Re: Forest Ridge Phase 1 (LPF-20-00005) Final Long Plat

This letter is to address your December 29<sup>th</sup>, 2020 letter requesting additional information. Below is a description of how each request is being addressed by the applicant:

LPF-20-00005

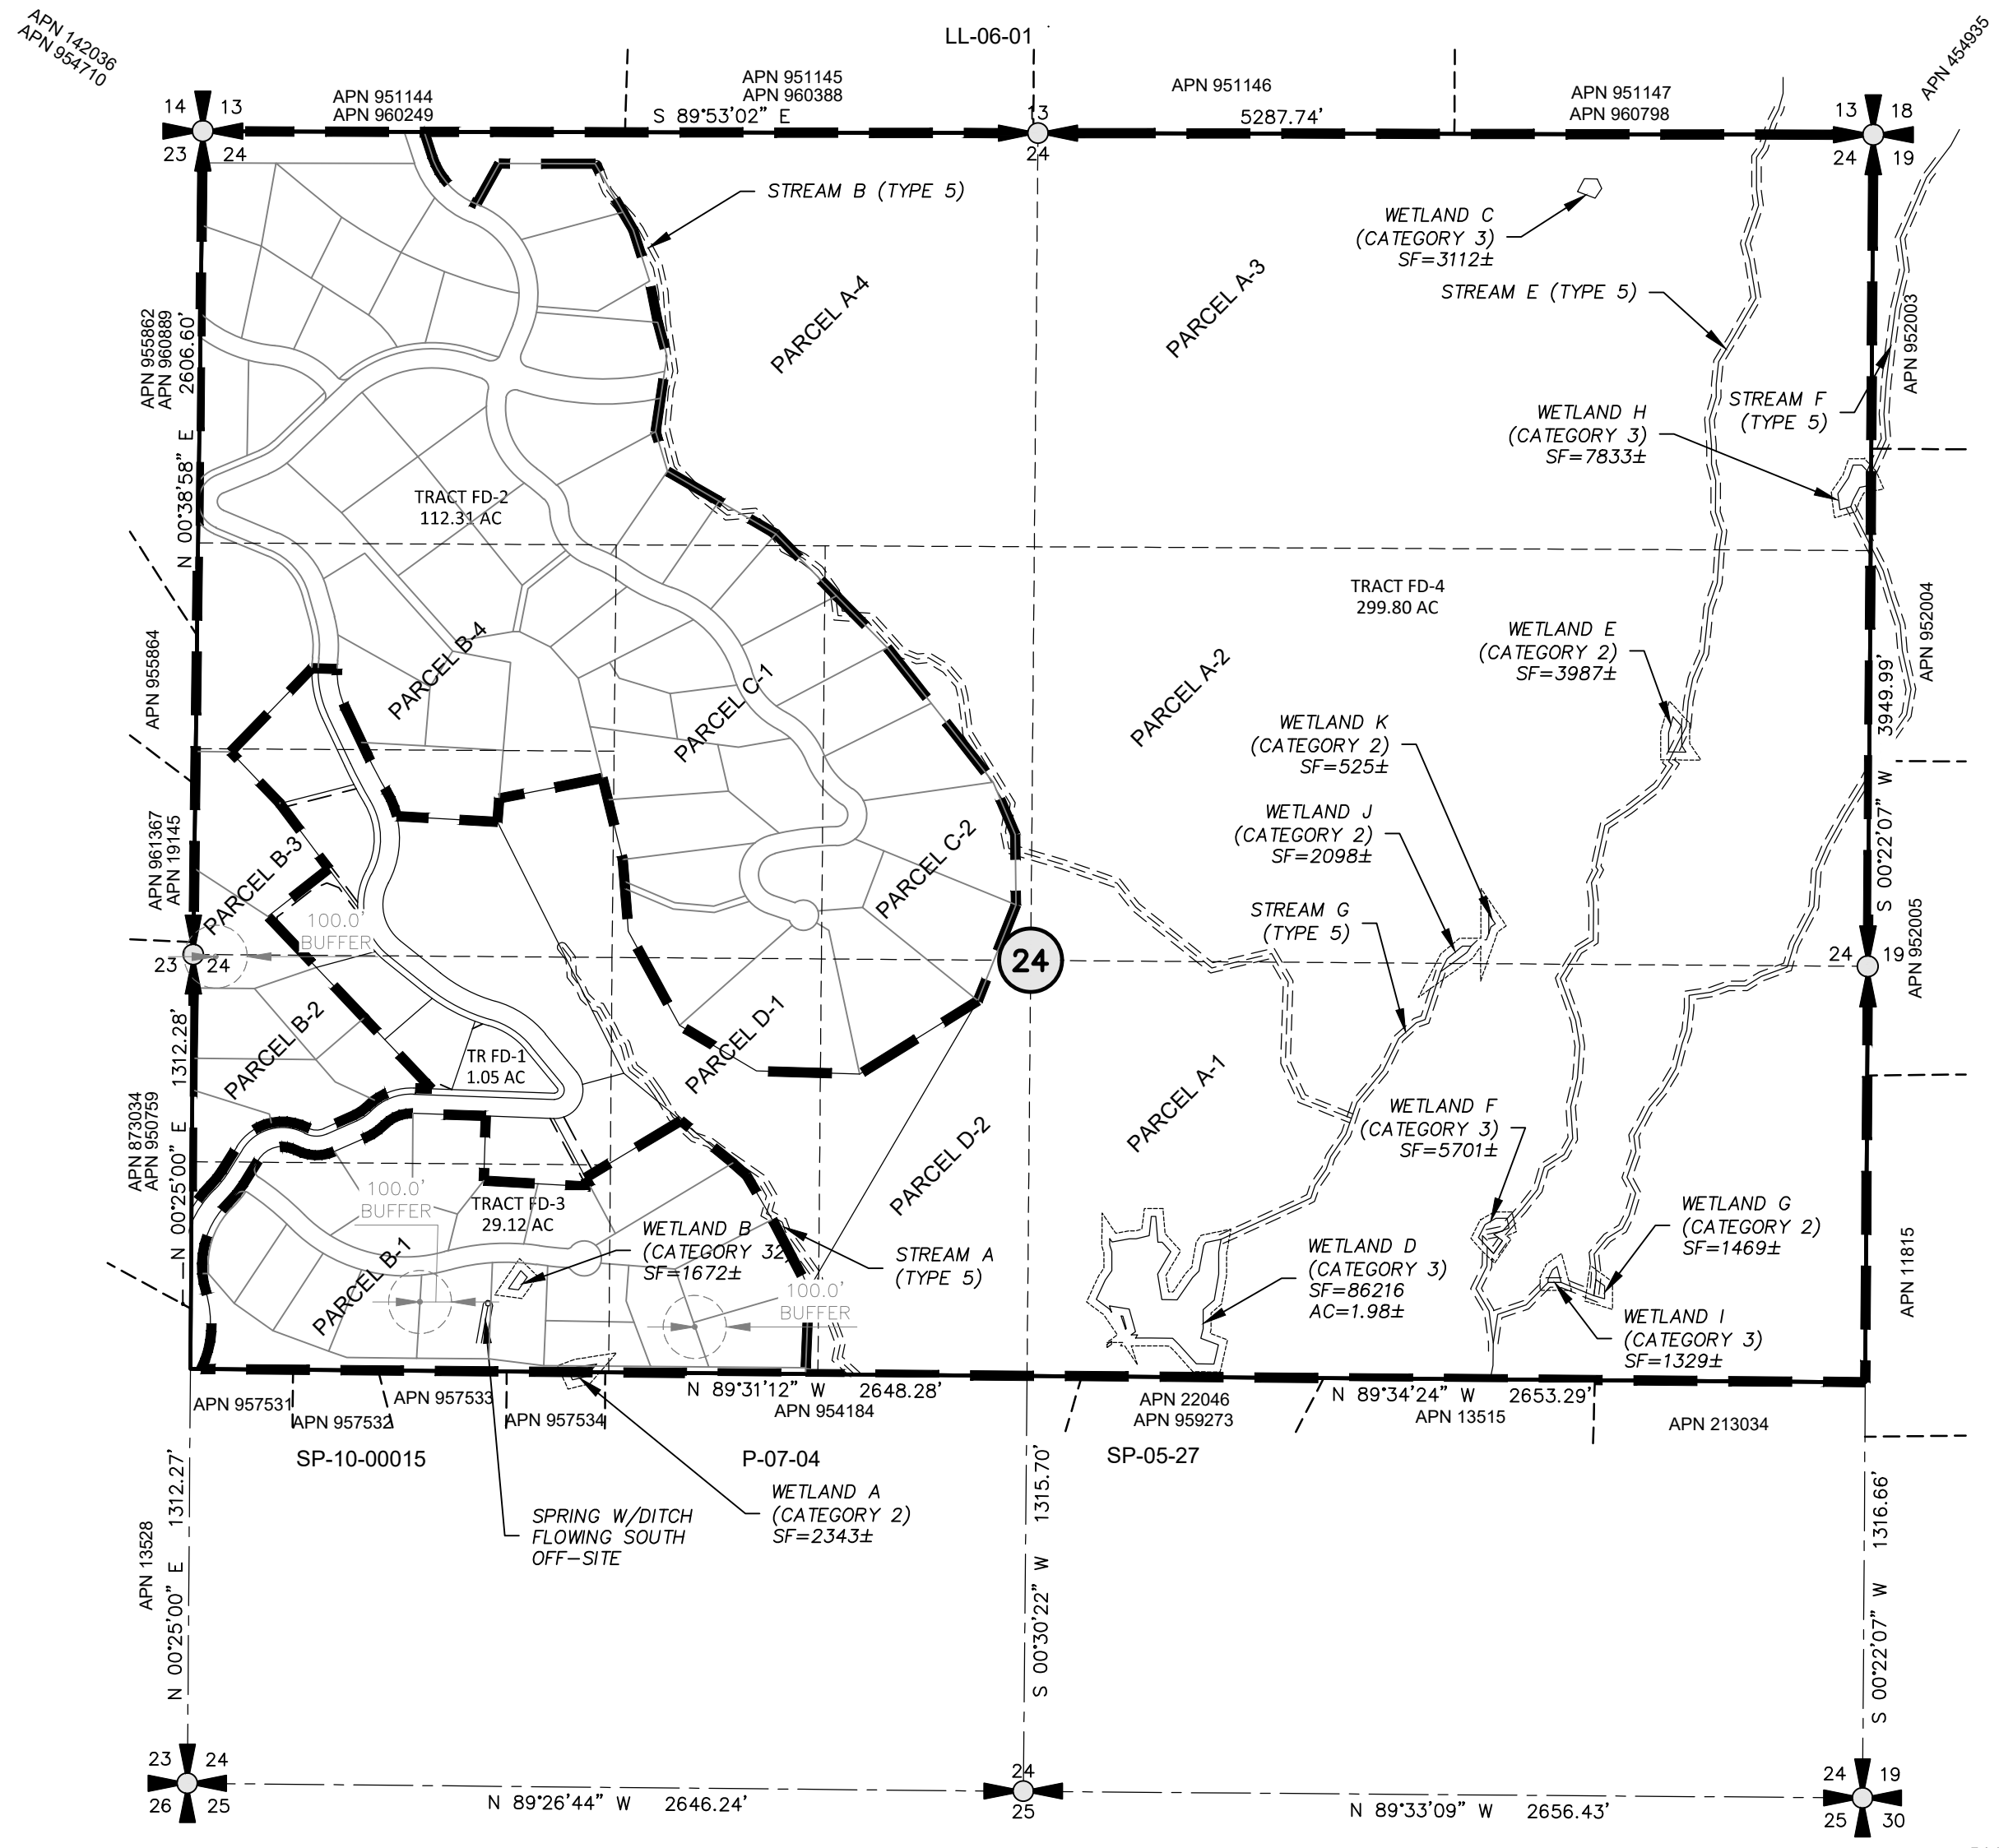
- *Final mylars shall include the final plat number LPF-20-00005. **See update plat maps with Plat #***
- *Resolution 2010-137 Condition 8 states, "Prior to final plat approval, the applicant shall present to the County for review and approval a map demonstrating that at least 40% of the total plat area meets the open space requirements of Chapter 16.09." The condition compliance document provided notes that this map is included in the submittal materials, but staff couldn't locate this. **See enclosed narrative and open space compliance map.***

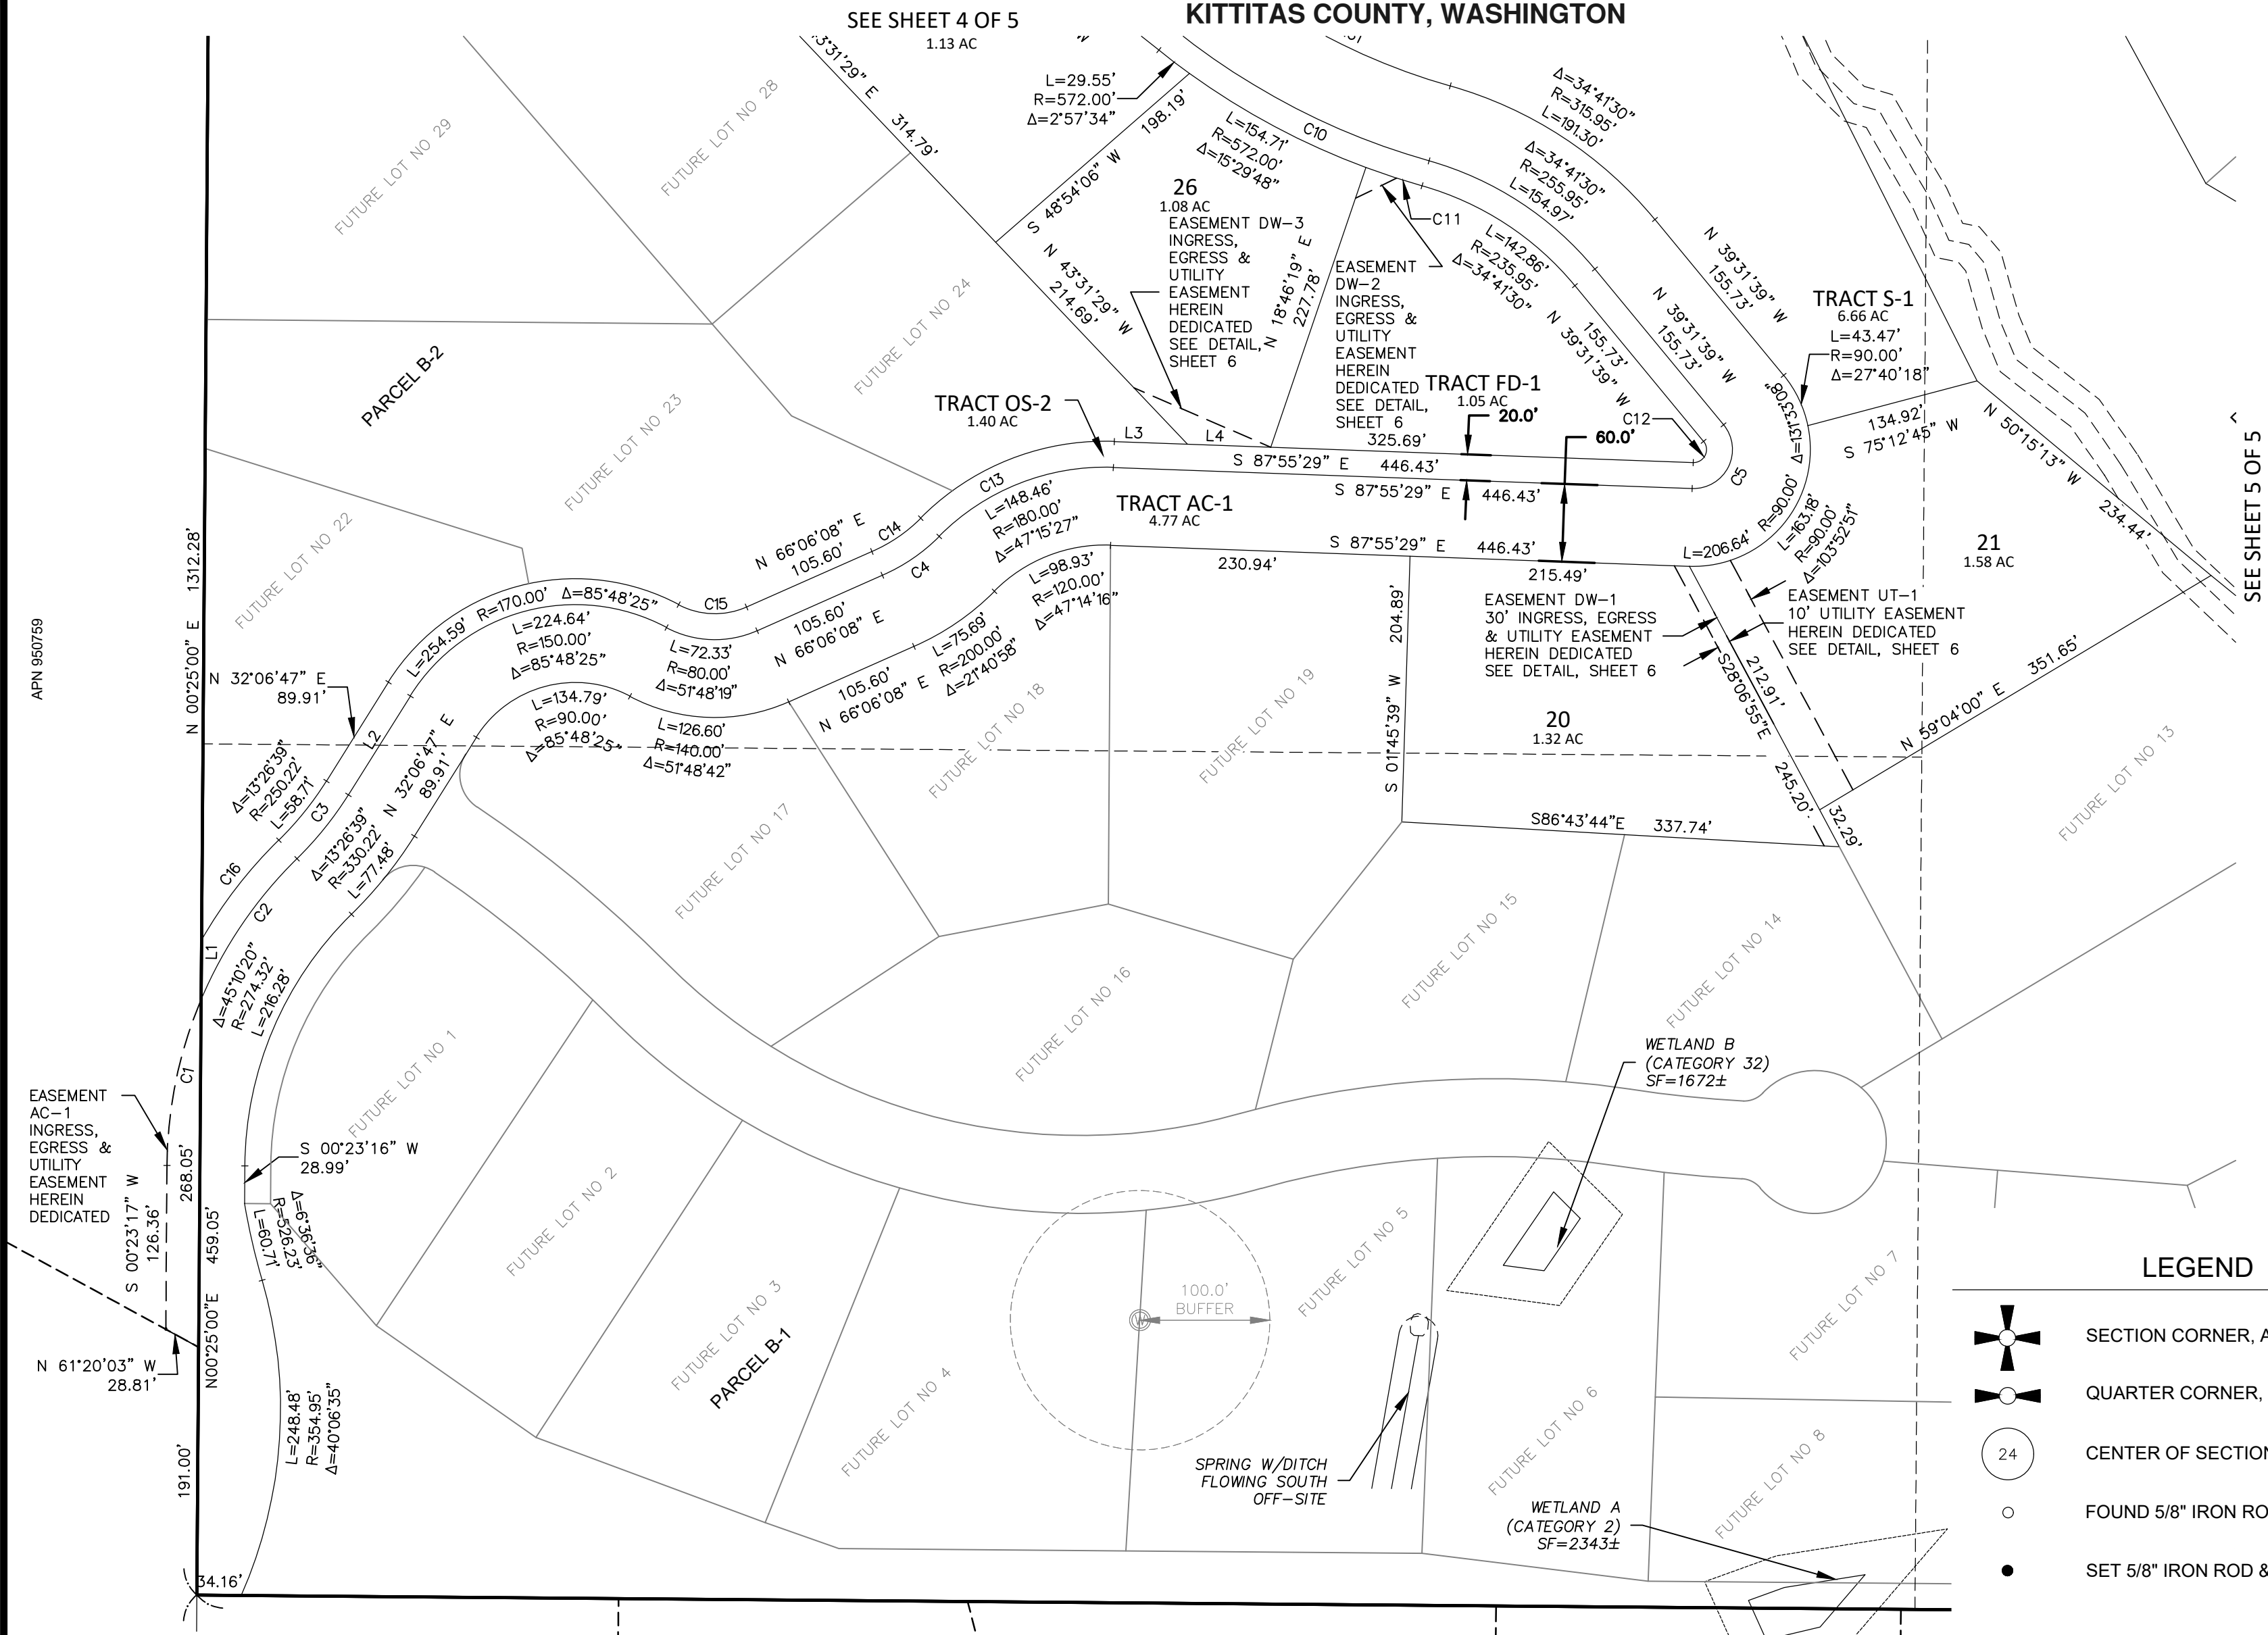
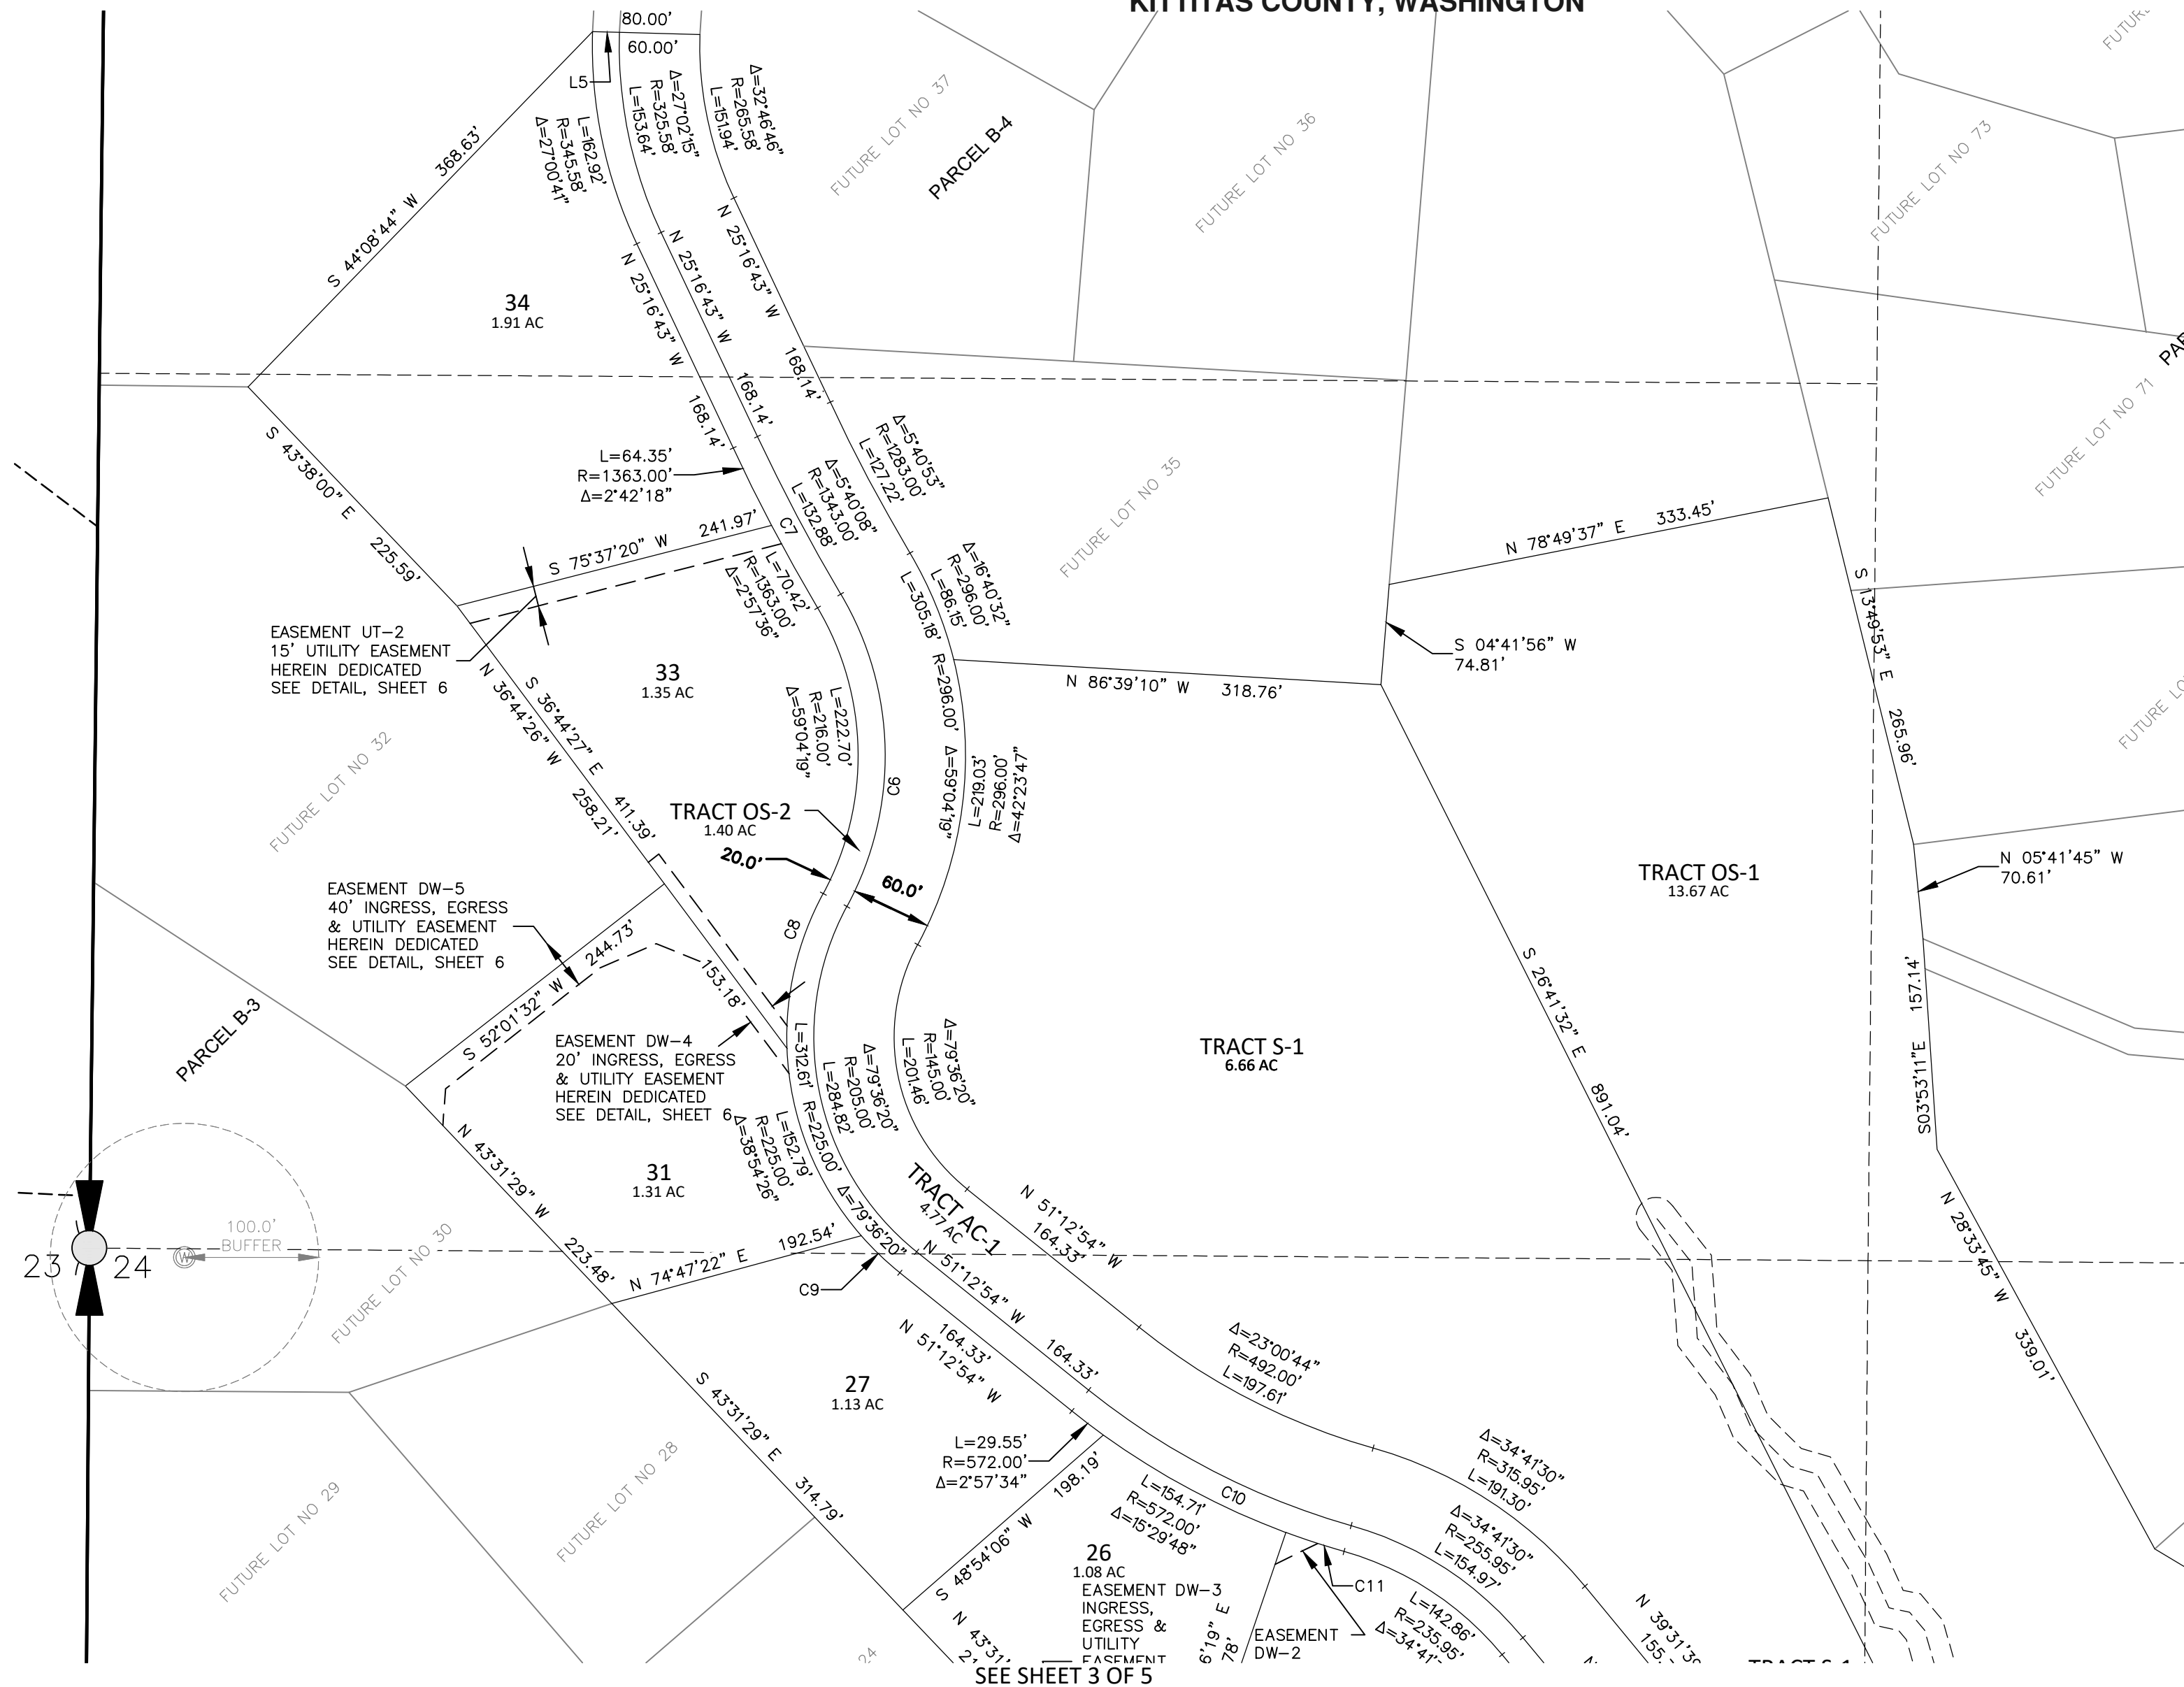
- *Wetlands "A" and "B" as depicted on the attached wetland inventory map are not noted on the preliminary survey. Condition #11 of Resolution 2010-137 requires, "All wetland areas and their buffers shall be shown on the face of the final plat." **See enclosed plat map with Wetlands "A" and "B" shown.***
